August 26, 2019

**RE: Water and Sanitary Sewer Availability Statement #190701
Milagro Site Development
10000 Central Ave SW**

ISAACSON & ARFMAN, P.A.
 Consulting Engineering Associates
 128 Monroe Street N.E.
 Albuquerque, New Mexico 87108
 Ph. 505-268-8828 www.isaacson.com
 2306 CU-101.dwg Mar 25, 2019

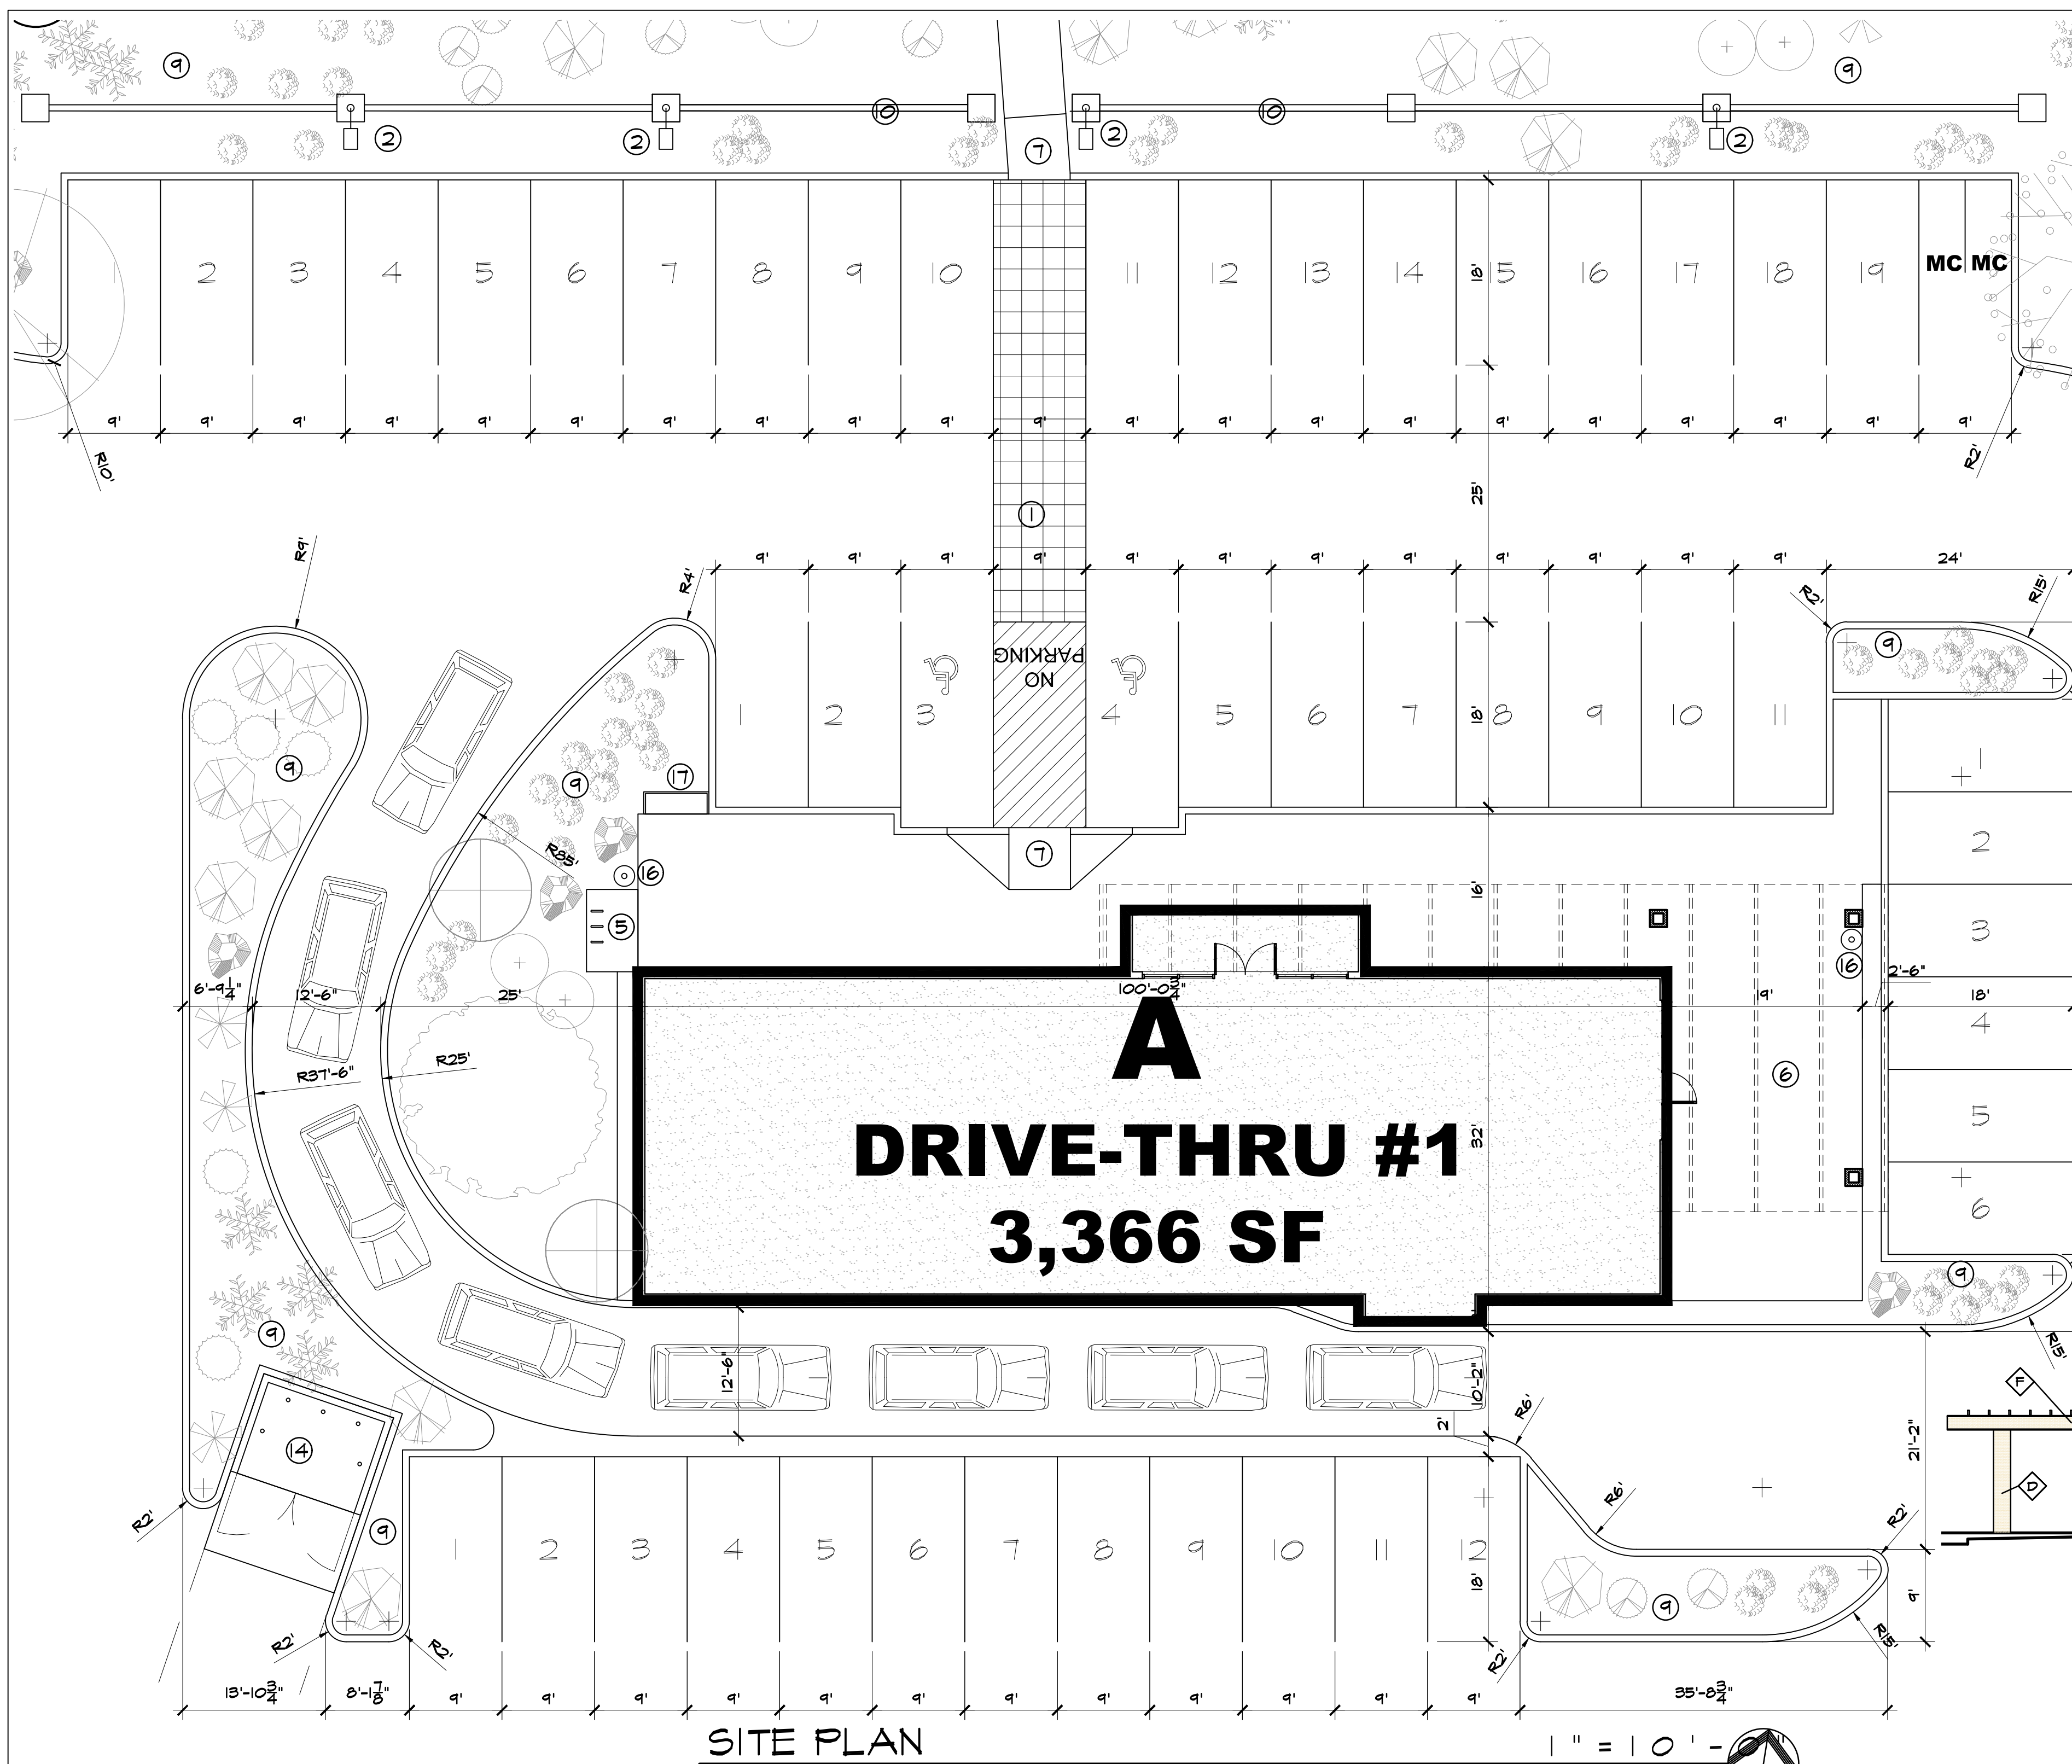
Water Service: New metered water service to the property can be provided via routine connection to the existing line along Sunset Gardens. Per the preliminary building permit utility plan, Isaacson & Arfman designed a second line which connected to the transmission main along Central Avenue. However, Albuquerque Bernalillo County Water Utility Authority prohibits connections to transmission lines.
